A30 Chiverton to Carland Cross TR010026

8.24 REQUEST FOR NON-MATERIAL AMENDMENTS TO THE DRAFT DCO

June 2019

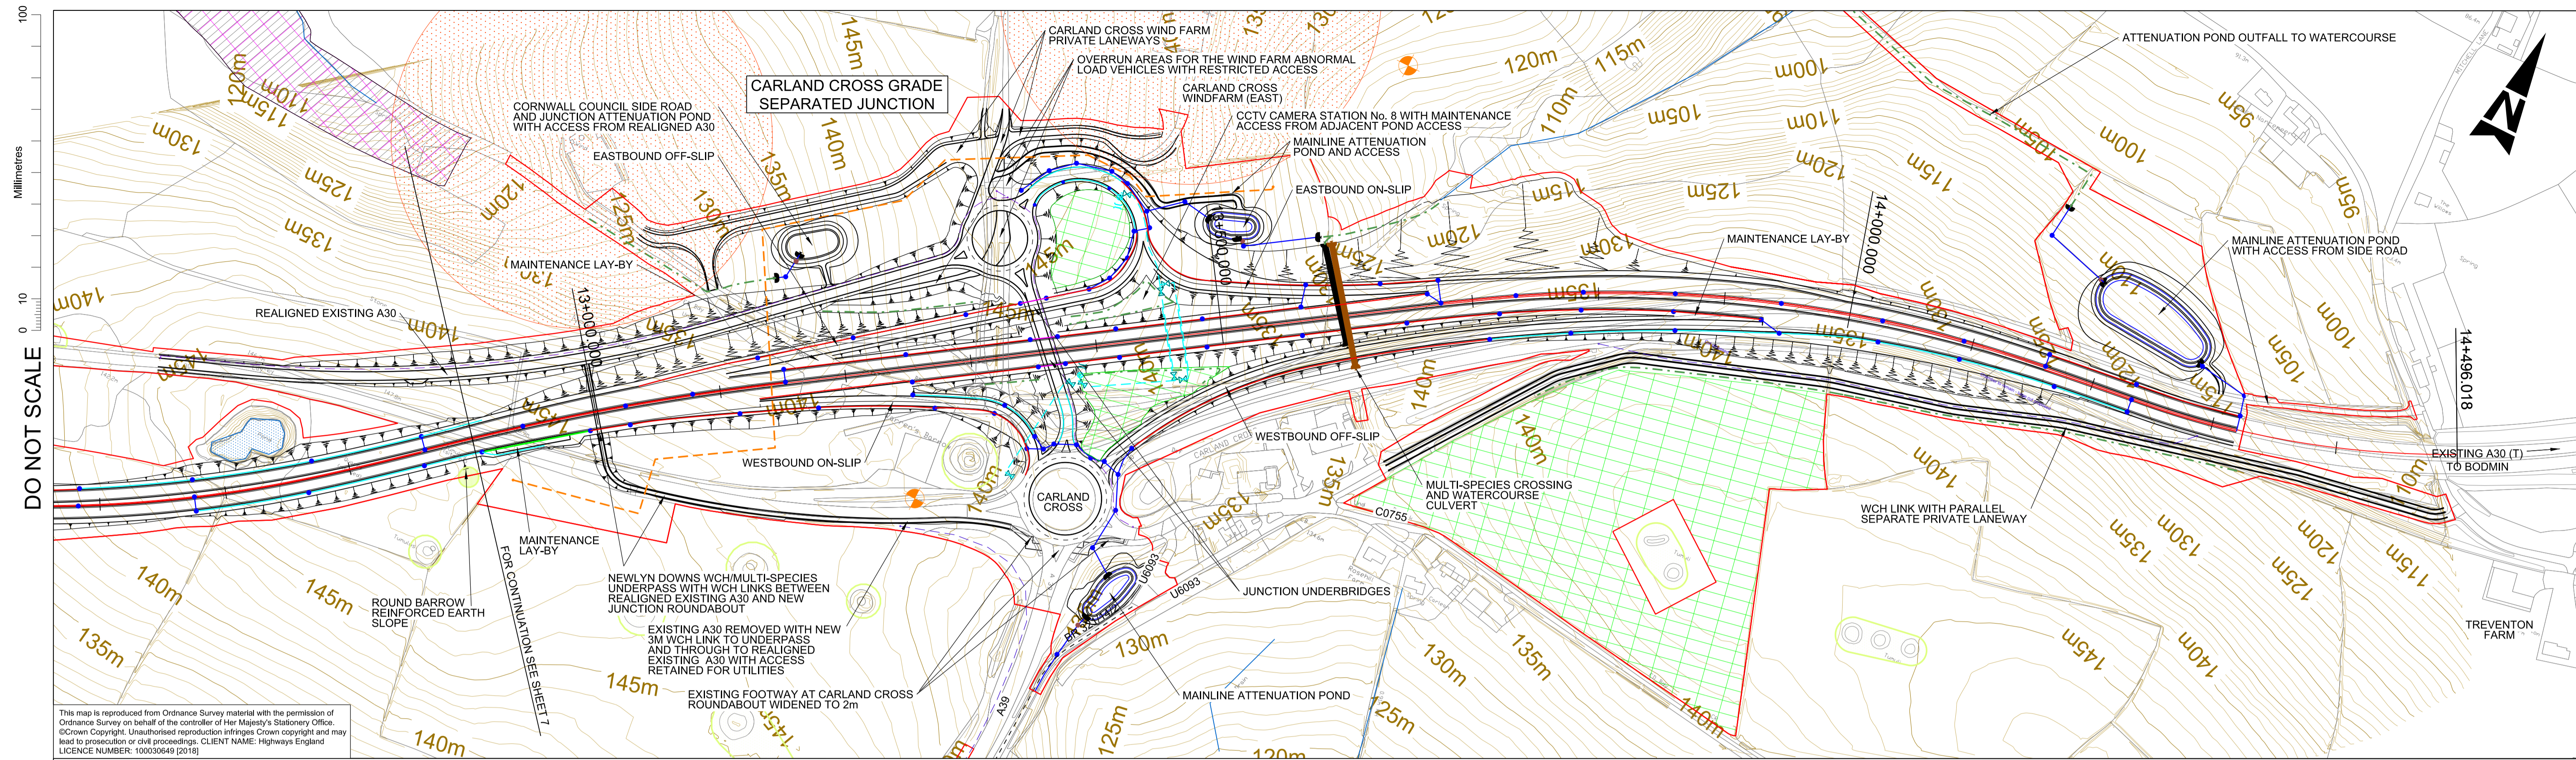
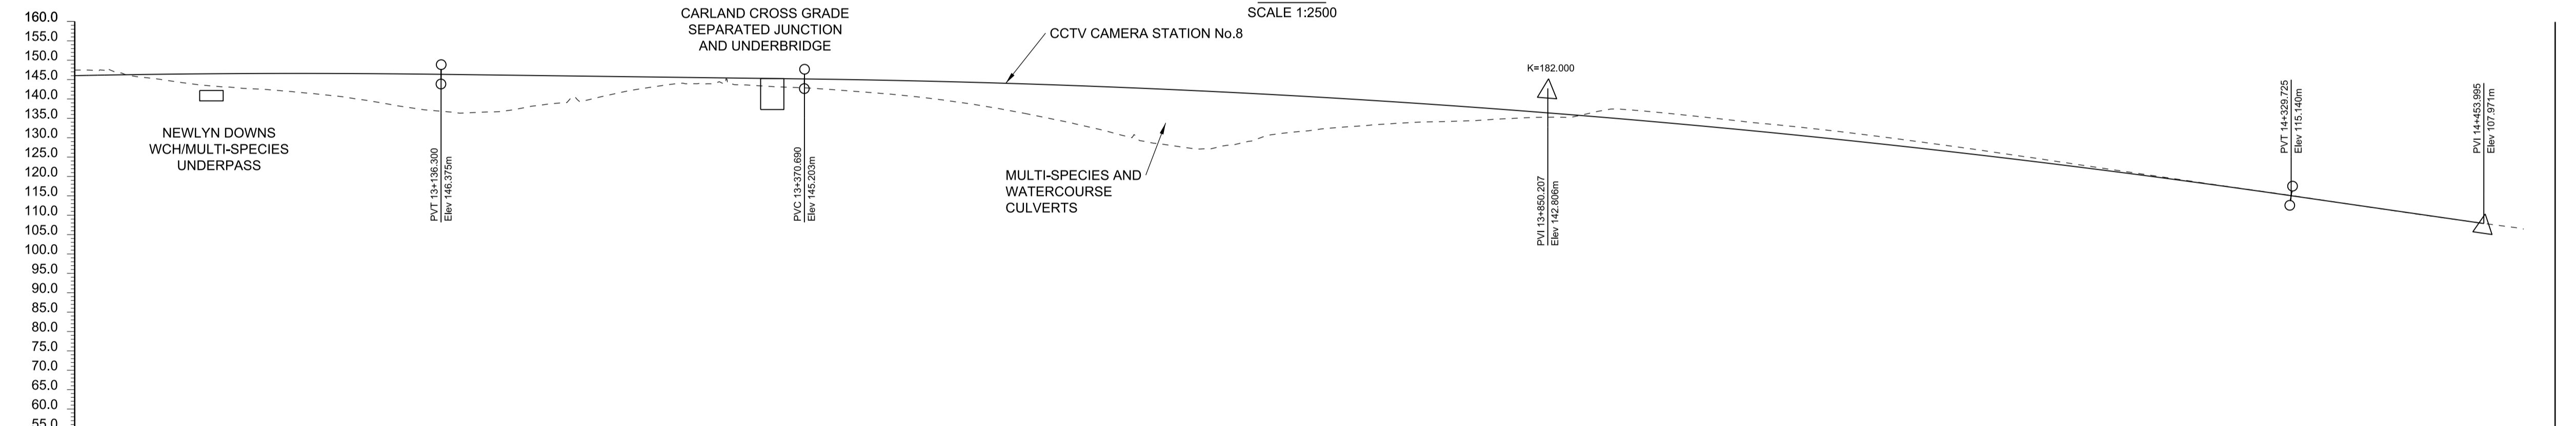
2.5(D)	Rights of Way and Access Plans, Complete Set	Sheet 8 Amended layout to incorporate Reference WW and addition of label for WW and PR16
2.6(B)	General Arrangement and Section Plans, Complete set	Sheet 8 Amended layout to suit new access west of existing Carland Cross roundabout

2.4(D)	Works Plans, Complete Set	Sheet 8 Amended layout to suit realigned Bridleway and addition of label for Work No. 5o
2.5(D)	Rights of Way and Access Plans, Complete Set	Sheet 8 Amended layout to suit realigned Bridleway east of existing Carland Cross roundabout

2.6(B)	General Arrangement and Section Plans, Complete Set	Sheet 8 Amended layout to suit realigned Bridleway and addition of WCH label
3.1(E)	Draft Development Consent Order	Schedule 3- Part 8 (column 1) Additional Parish Council inserted: St Newlyn East St Erme, Civil Parishes Schedule 3- PART 8 (column 2) Reference VV (PR15) Amended description as “1127 metres bridleway as shown on Sheet 8 of the Rights of Way and Access plans” Schedule 4- Part 2 (column 1) Additional Parish Council inserted: St Newlyn East St Erme, Civil Parishes Schedule 4 Part 2 (column 4) Reference VV (PR15) Amended description as “A new bridleway south of the existing A30(T) to its junction north of Treventon Farm, for a total length of 1127 metres” Schedule 7 Plots 9/1v, 9/1x and 9/1z added
